2023/0559

Description: Erection of 1no dwelling on land to the rear of 64 Granville Street (Outline with all matters reserved)

Site Address: Land to the rear of 64 Granville Street, Old Town, Barnsley, S75 2TQ

Location Plan

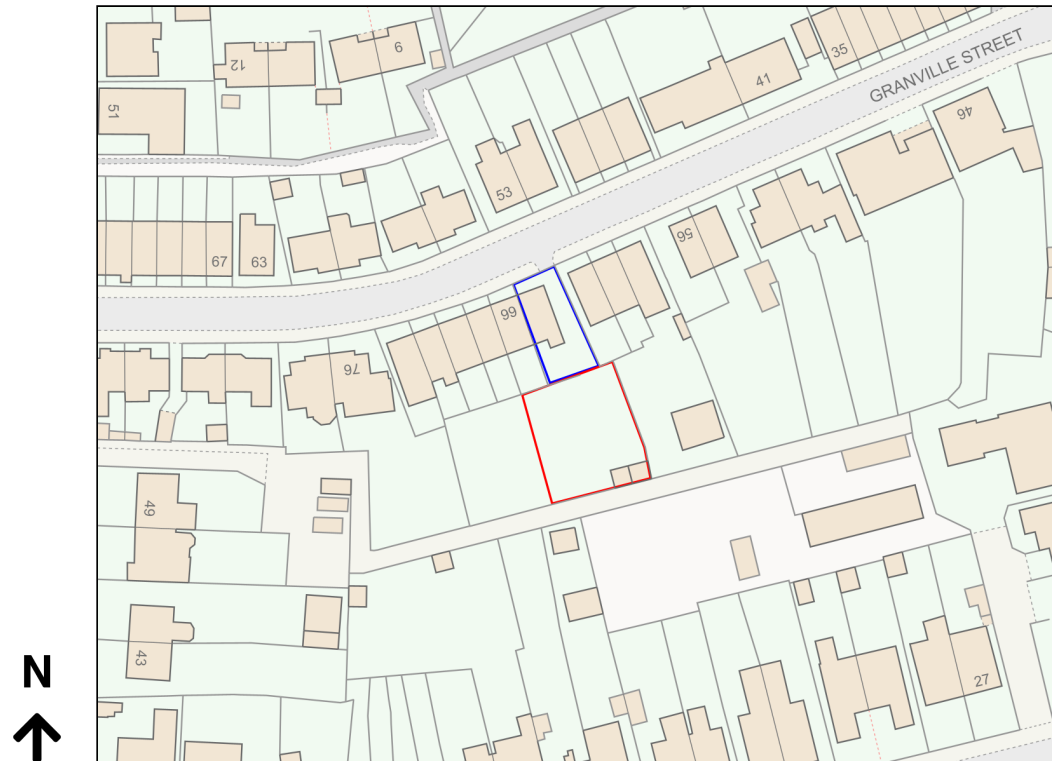
It should also be noted that the red line boundary does not include a link to the public highway.
